Rezoning Transportation Analysis
Petition Number: Insert Zoning Petition #2021-224
General Location Identifier: 10812102

Revision Log:

Date	Description
02-18-2022	First Review (AO)
03-23-2022	Second Review (AO)

Transportation Summary

REZONING PLAN

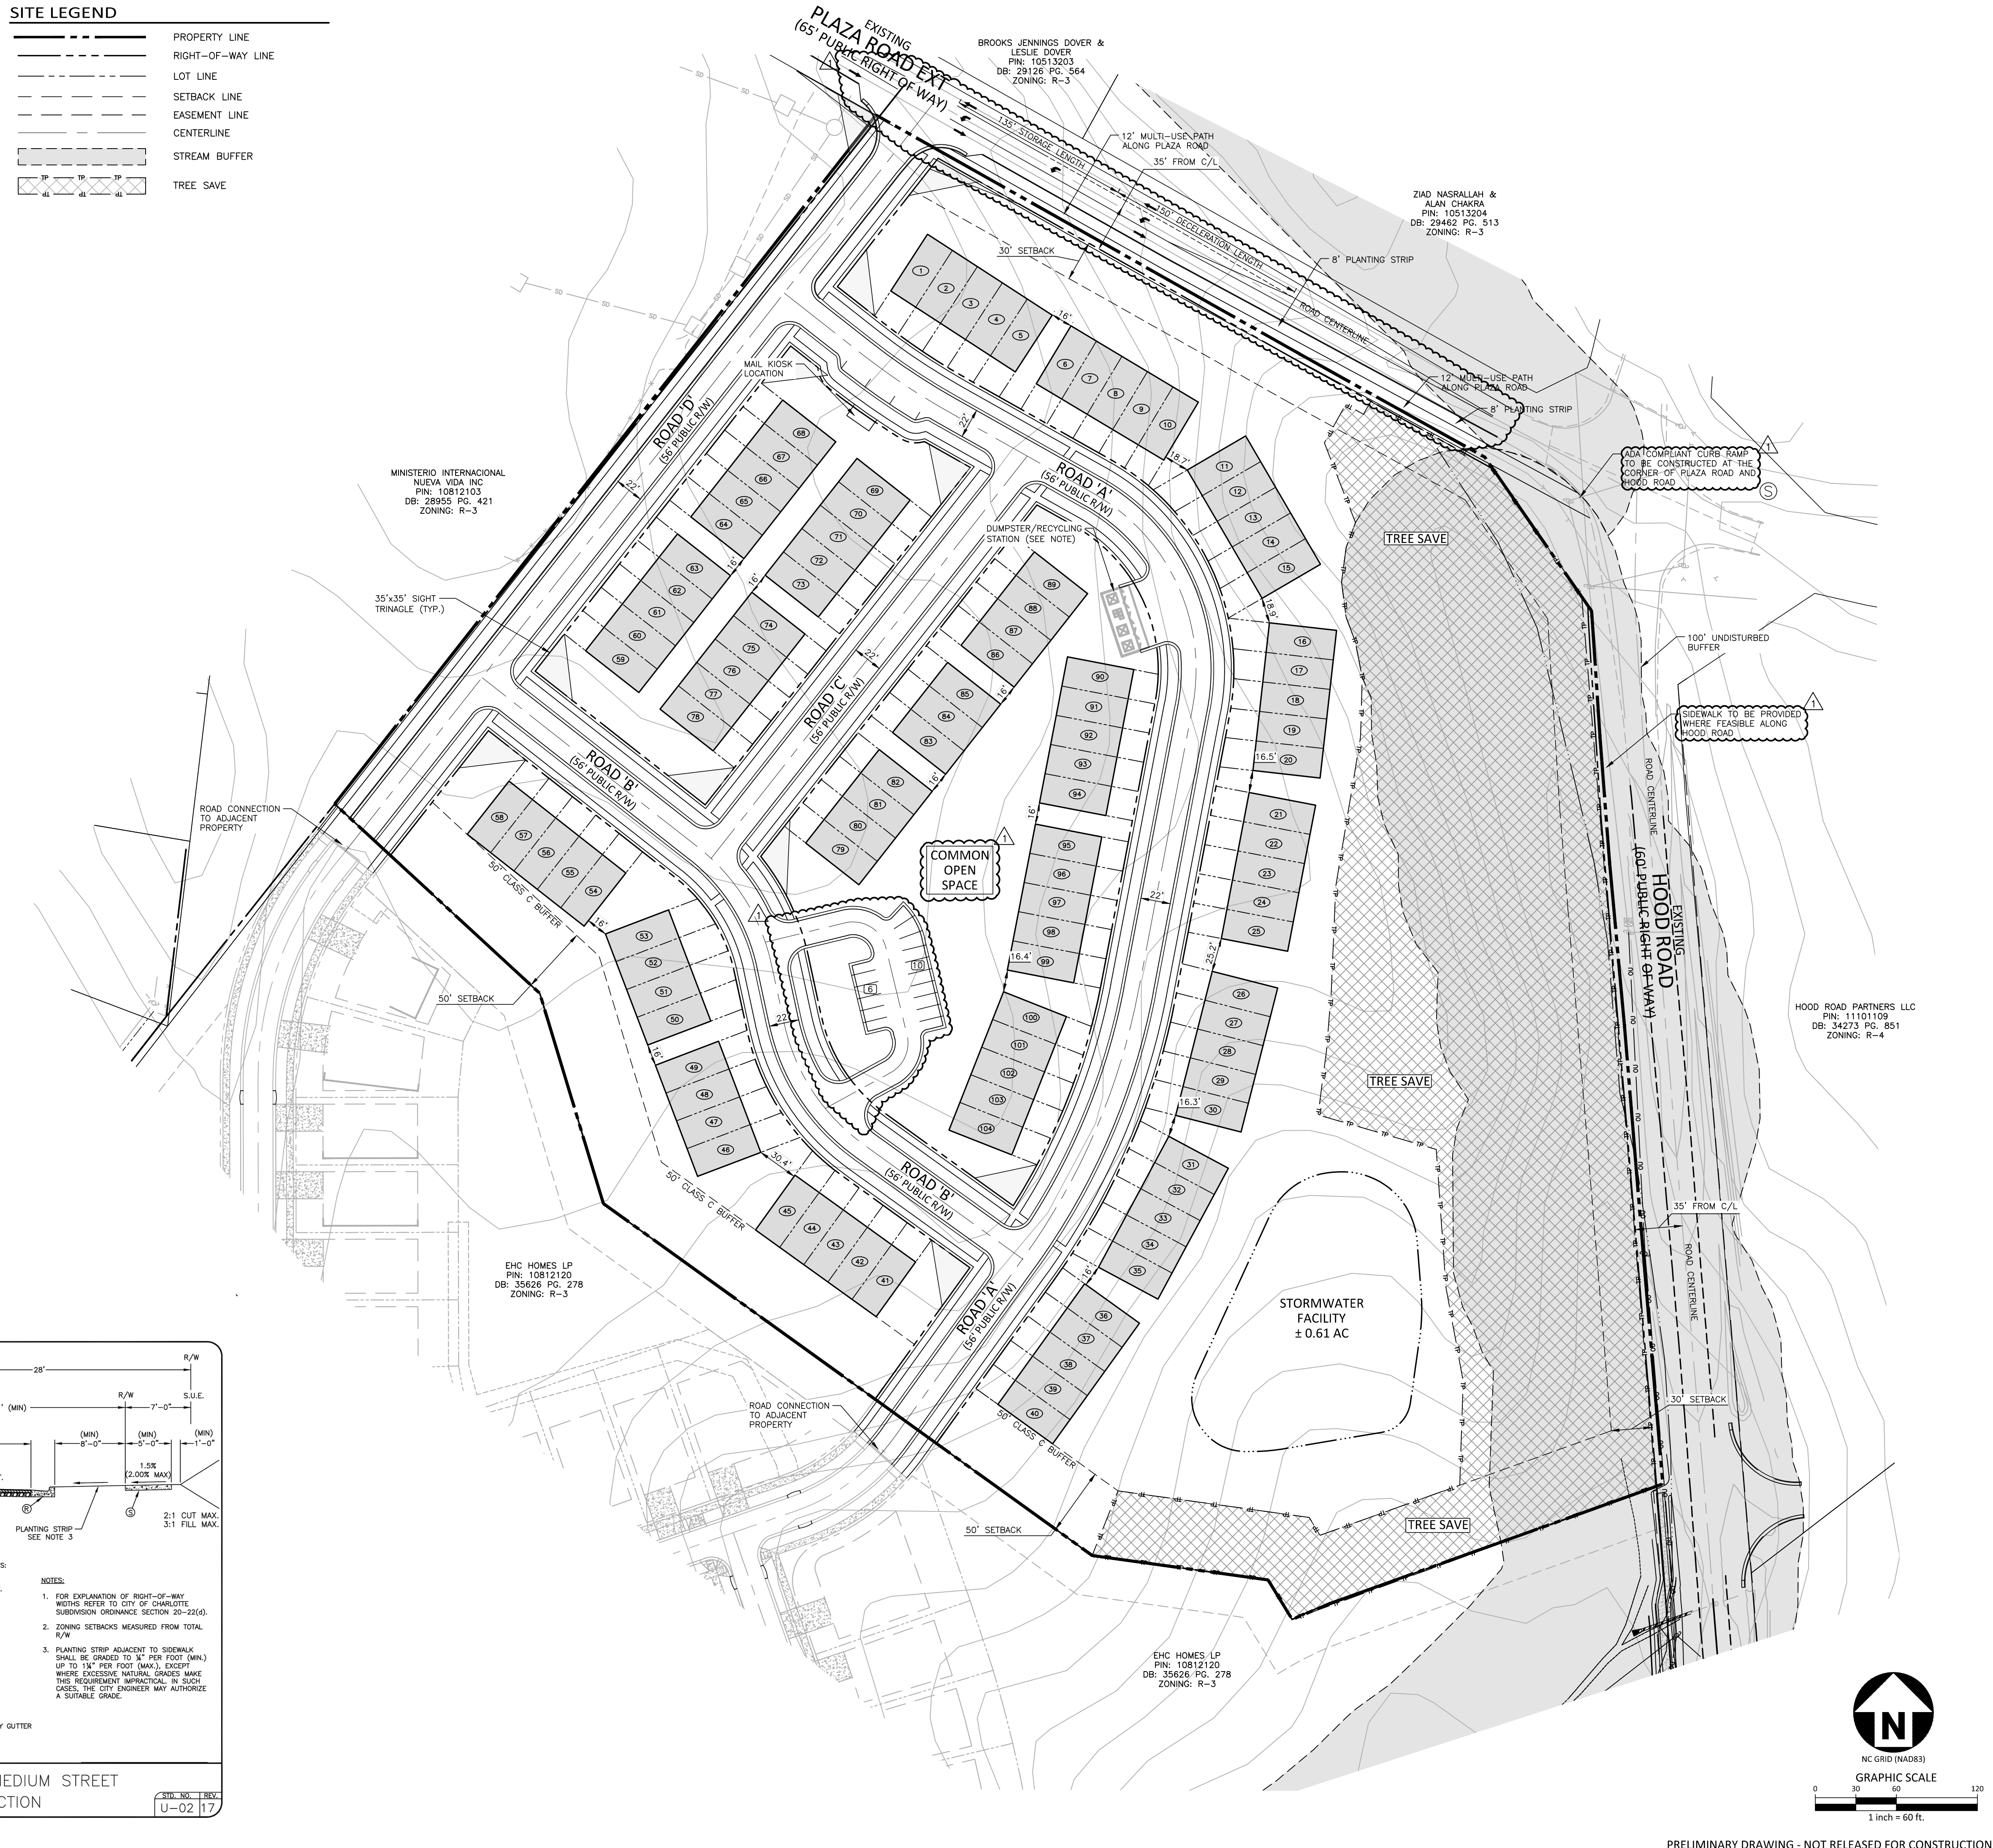
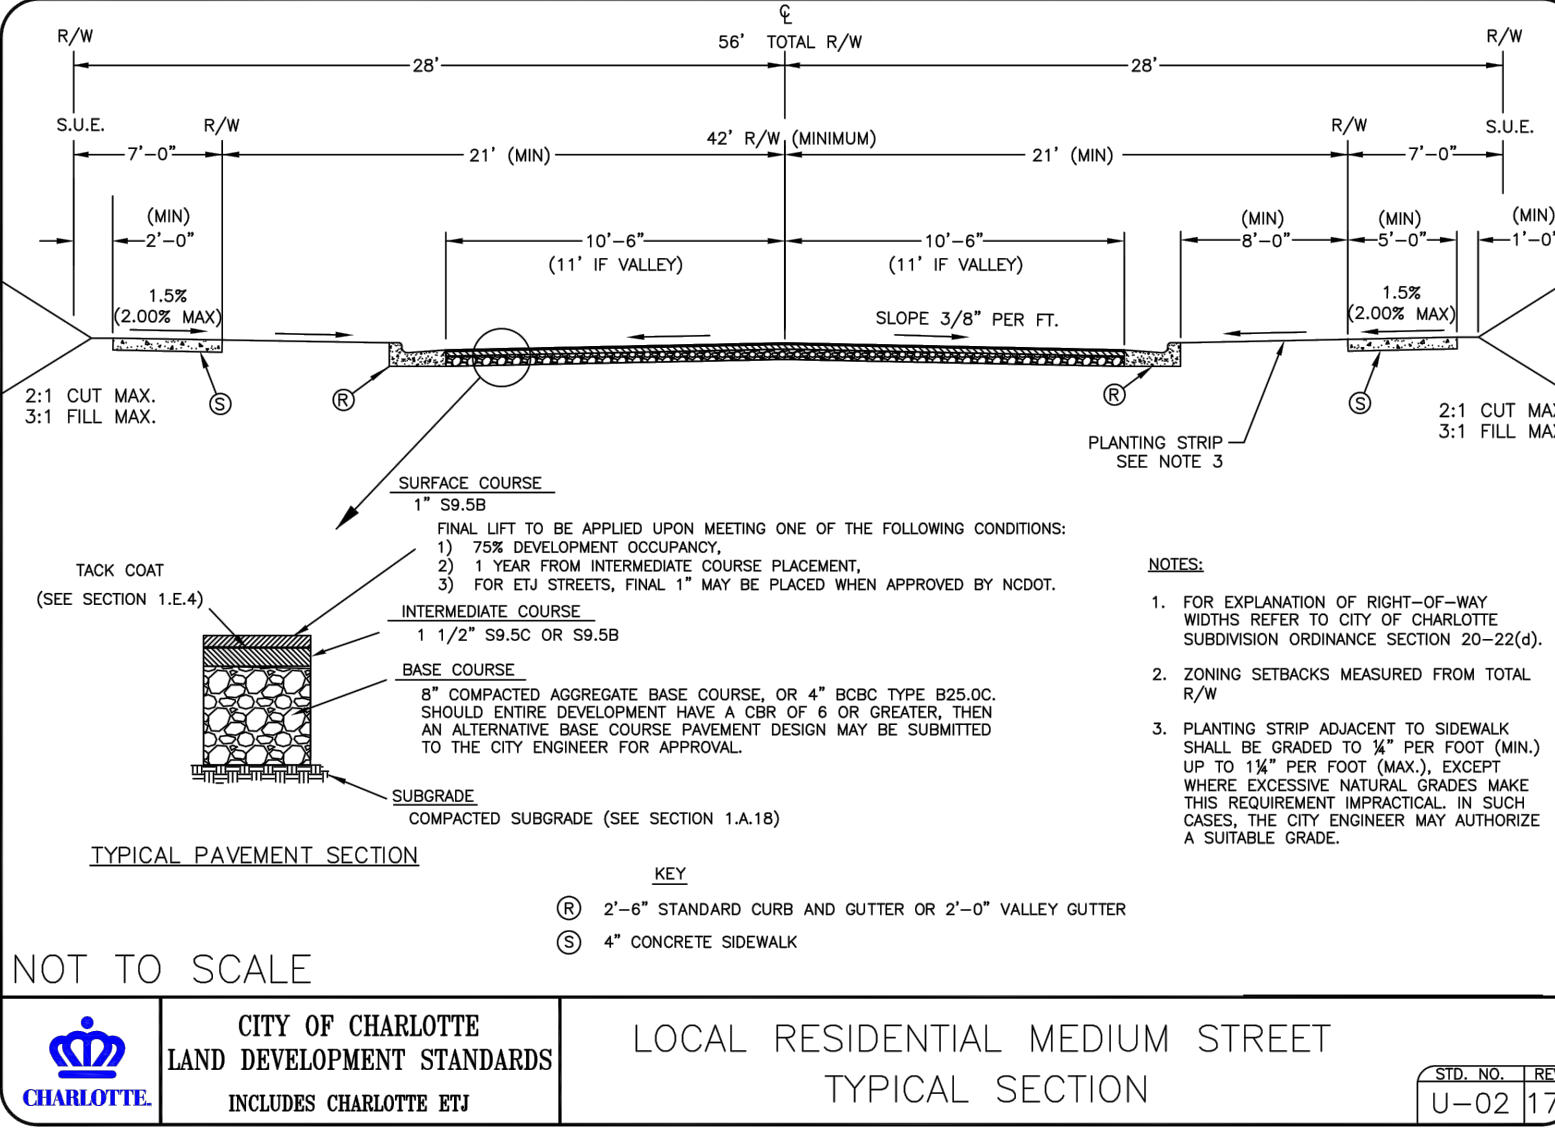
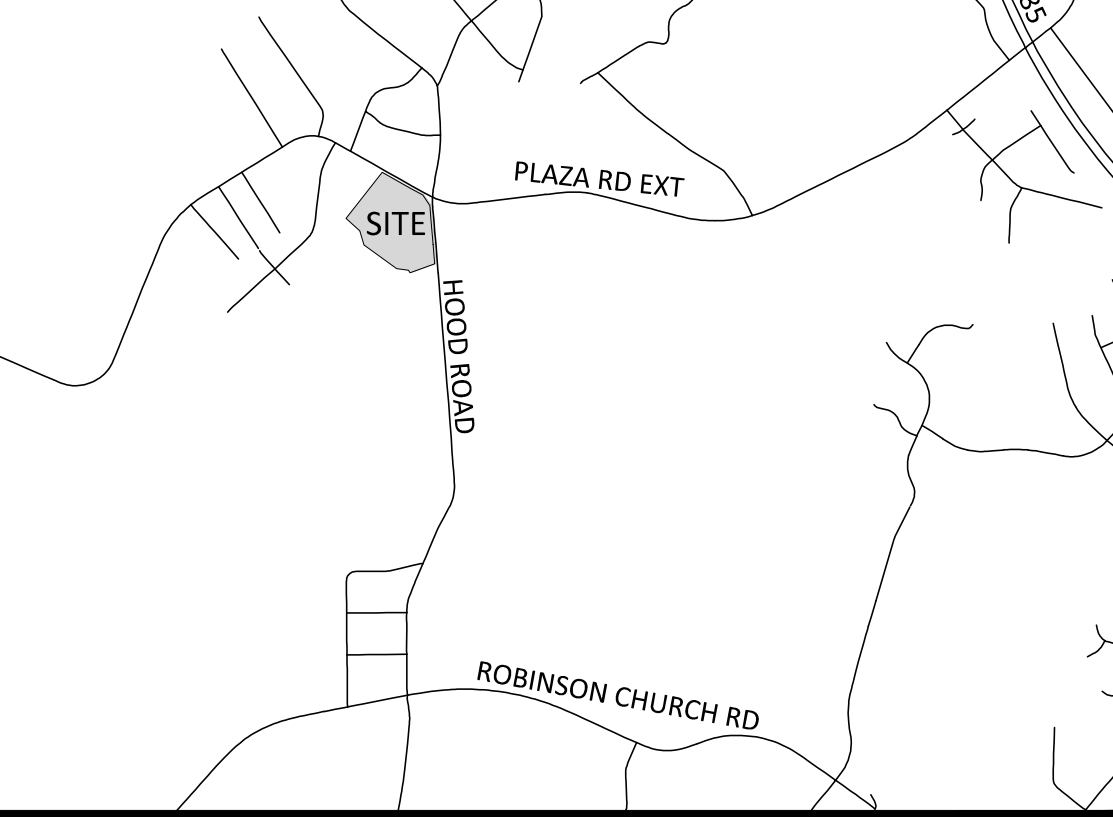
2. **Outstanding Comment from 02-18-2022:** Revise site plan and conditional note(s) to commit to construct an 8-foot planting strip, and 6-foot sidewalk on Hood Road per Chapter 19 / Chapter 20. The site plan shall label and dimension both items from road centerline.

3. **Outstanding Comment from 02-18-2022:** Revise site plan and conditional note(s) to commit to constructing a left-turn lane with 150' of storage on Plaza Road into the site.
Update to Comment (New Site Plan, 3-14-2022): If anything outside of the requirement above has been coordinated with NCDOT, CDOT would need documentation of the agreed upon condition.

- 5. Revise site plan and add conditional note to show that no trash collection will be accommodated within the public rights of way.
Update to Comment (New Site Plan, 3-14-2022): If roll out trash and recycling containers aren't utilized, dumpster/ recycling station shall be located and accessible without maneuvering in the public right-of-way. Current setup doesn't appear to reflect this scenario.

- 7. Revise site plan to construct a 6-foot sidewalks and 12-foot multi-use path on Plaza Road and Hood Road. The site plan shall label and dimension both items from the back of curb and gutter and road centerline. The entire facility must be outside of the right of way and within a public access easement. Add conditional note committing to construction and maintenance of the 6-foot sidewalk and 12-foot multi-use path on Plaza Road and Hood Road.
Update to Comment (New Site Plan, 3-14-2022): Please see outstanding comment above, if the site will be annexed into the City this comment will not apply.
